10th January 2022

Application No: Y/127/21/RES
Site Address: Land at Bilsham Road Yapton
Description of works: Approval of reserved matters (appearance, landscaping, layout and scale) following the grant of Y/91/17/OUT for 250 No dwellings with associated parking, road/footway/cycleway provision, open space, landscaping, surface water attenuation & ancillary works (resubmission following Y/152/20/RES). This site is not CIL Liable as in Yapton Strategic Site.

Thank you for your internet representation made on 8th January 2022 which has been recorded as an objection with the comments as follows:

| A    | 091121 | Updated to suit revised layout P201 A | RP |      |      |            |    |         | 1:1000  | (A1 ORIGINAL) |       | Land Use Layout |   |

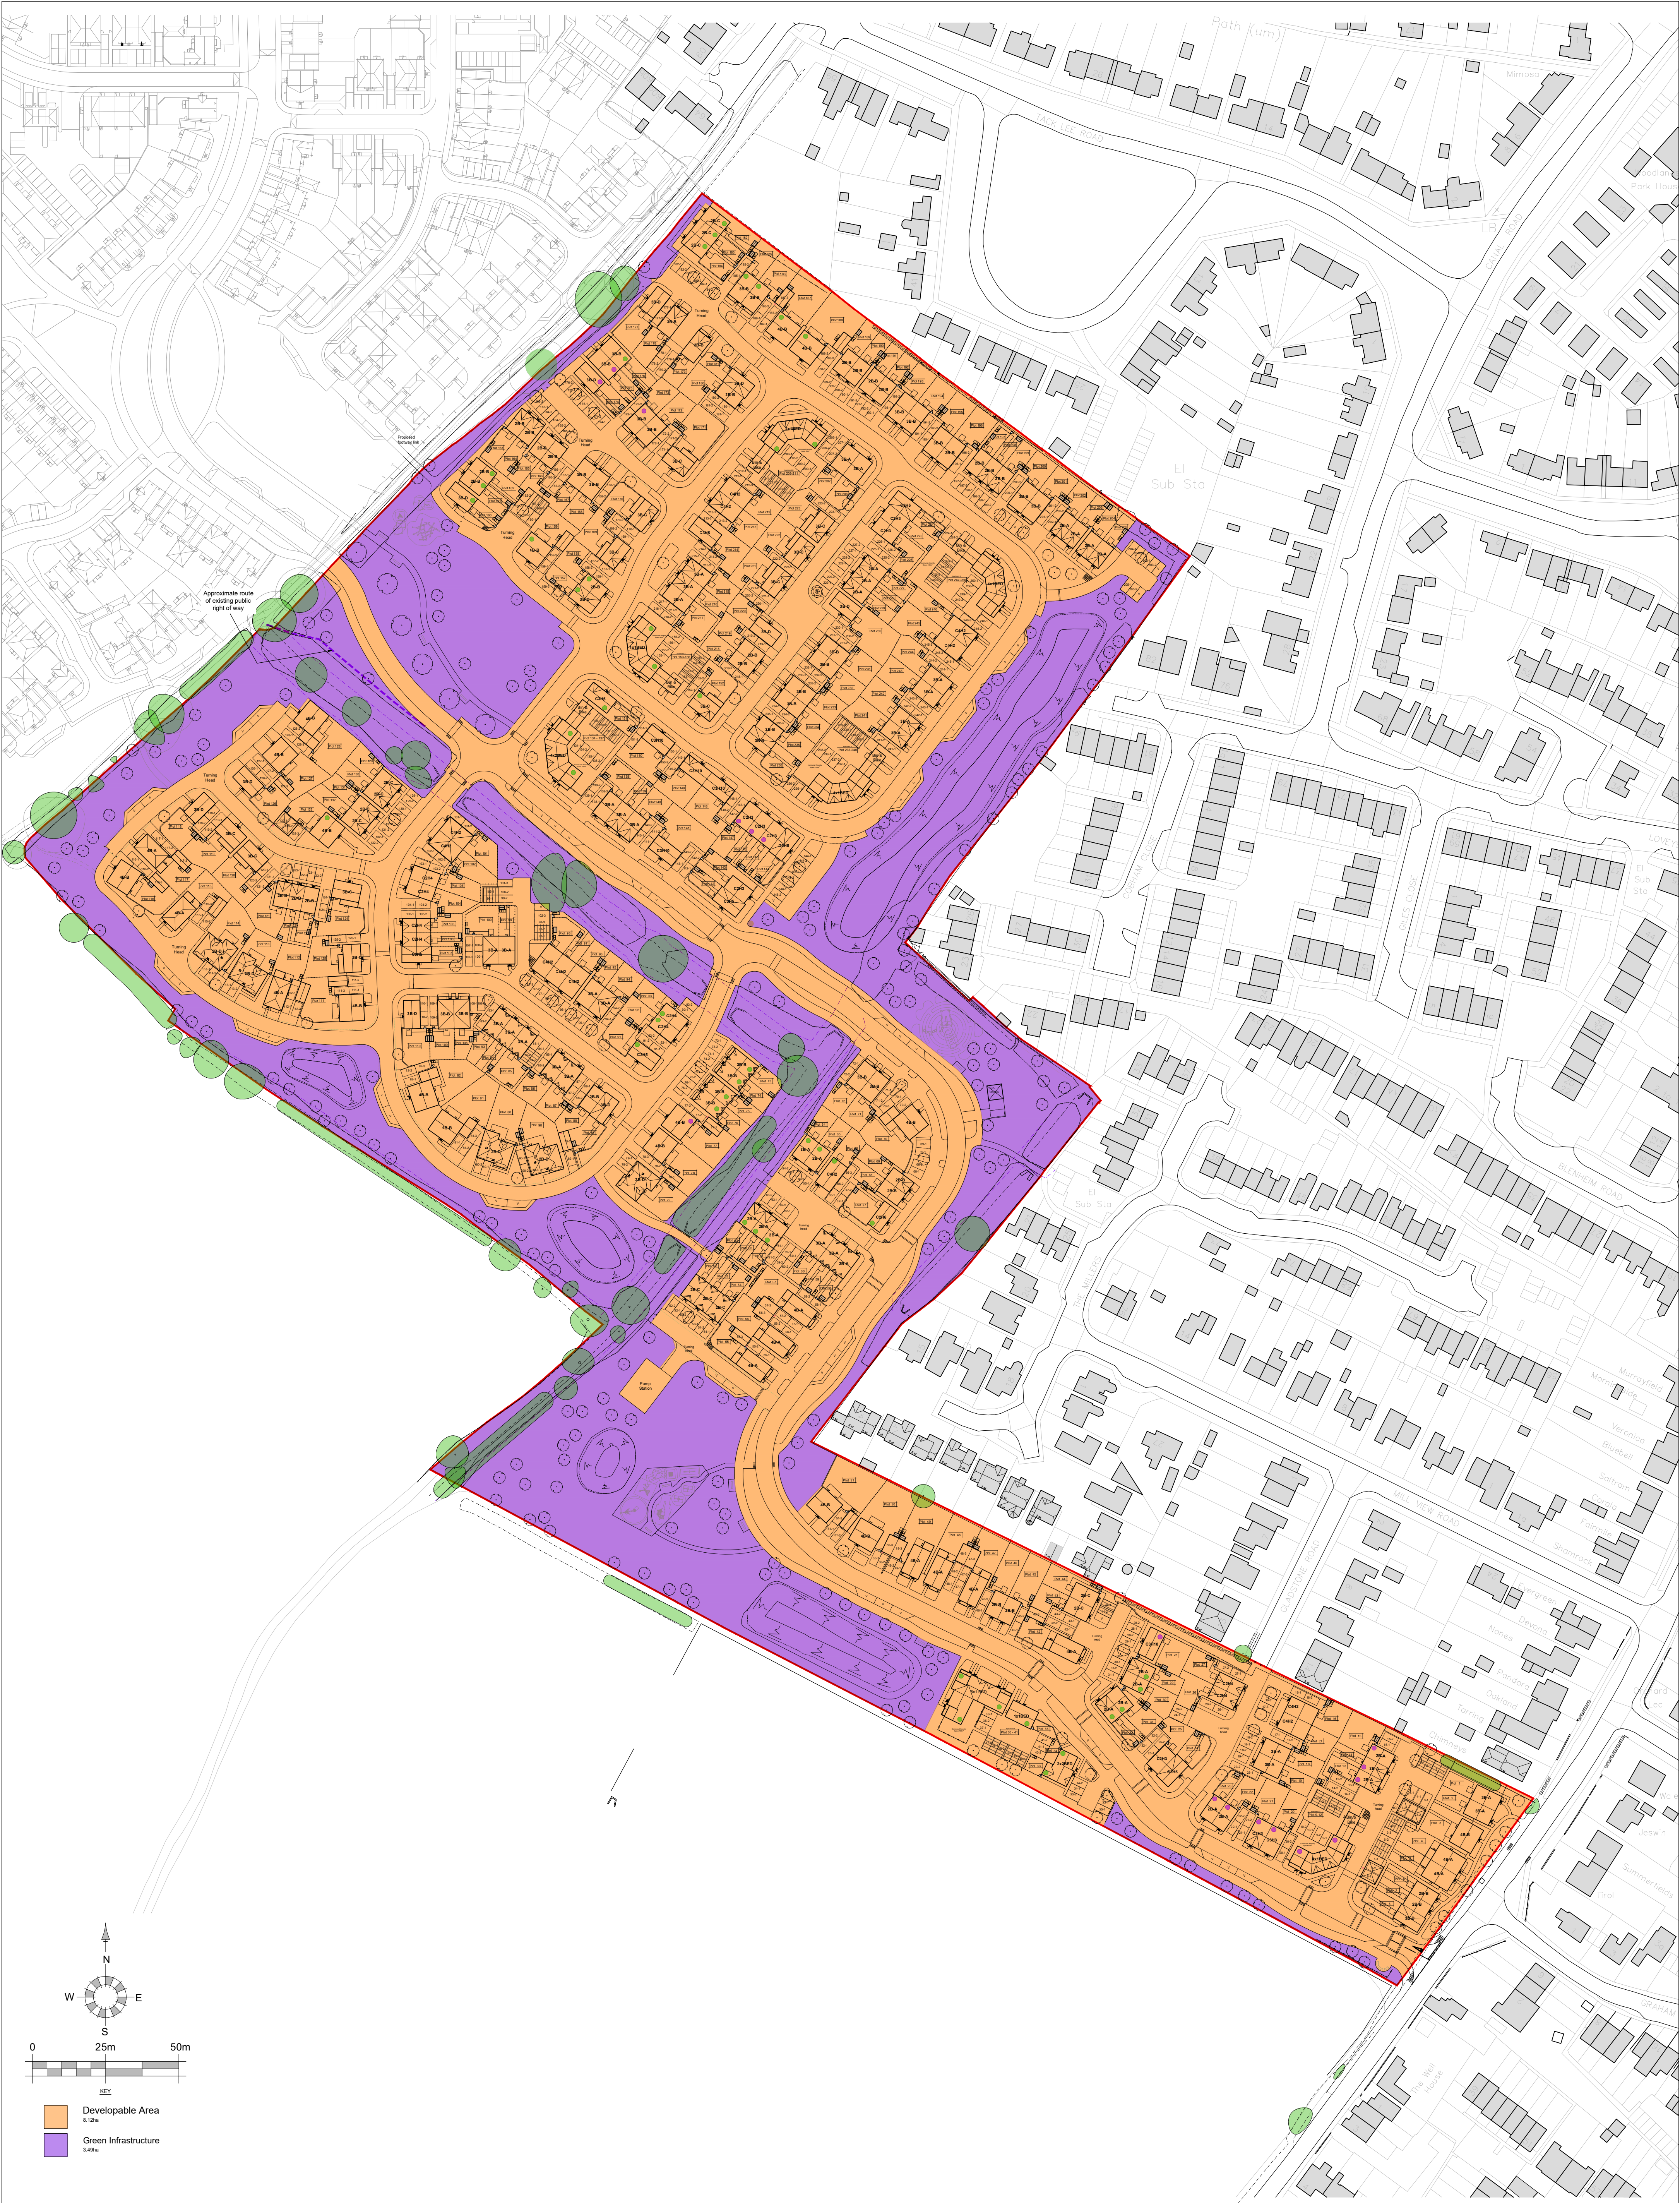
The original planning application showed 5 properties facing onto Bilsham road on the south east border of the development on Bilsham road. It now shows 9 with hardly any spacing between each property. This is not in keeping with the local character of Bilsham road where there are perceived spaces between each property or they are set back from Bilsham road engendering a feeling of space and openness when you enter the village from the south. Although in your revised plan dated 5/01/2022 you show a street scene that purports to show local character, this is in fact the centre of the development away from any through traffic and not on the frontage of Bilsham road.

The original density of buildings as shown in the original plan Y/91/17/OUT should be retained to prevent flash flooding and keep in the character of the village.

Drawing Title: **PRELIMINARY ENGINEERING LAYOUT. SHEET 1 OF 2**

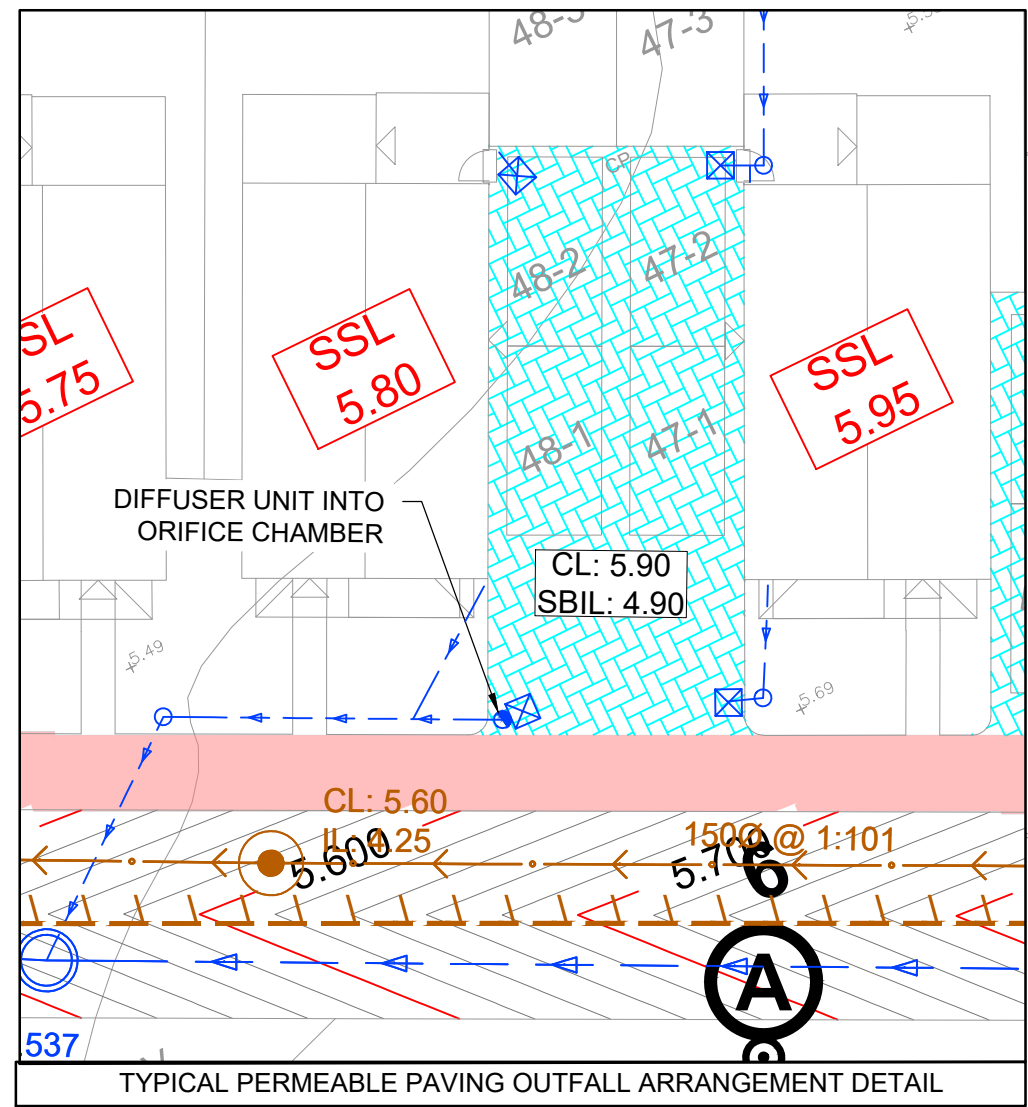
The SuDS water catchment areas have been enlarged in area/volume to compensate for the lack of soil permeability but the plan shows that permeable paving is still being relied on in the south eastern end of the development toward Bilsham road which will not work especially in a severe weather situation.

There are no SuDS areas planned in drawing 19-326/009 Rev.Q on the south eastern end of the site dated Feb 20. (this is an older drawing than previously submitted but submitted 05/01/2022). All of this area at present drains toward Bilsham road and during heavy spates of rain the whole road can flood for a short amount of time. I am concerned that there has now been an increase to the density of properties and roads in this area to compensate for the larger SuDS areas further into the site compared to the original application Y/91/17/OUT.

This I believe will increase the surface water run off causing more severe flooding in Bilsham road. There is now a further 27 properties and associated roadways and drives planned all draining onto Bilsham road in a small area, possibly causing water to enter some of the older properties that are near to the junction of the proposed Bilsham street/ Bilsham road junction. At present if there is a significant amount of rainfall the road floods all the way across in the frontage along the Bilsham road and now if this density of housing toward the Bilsham road end is increased the matter will get significantly worse.
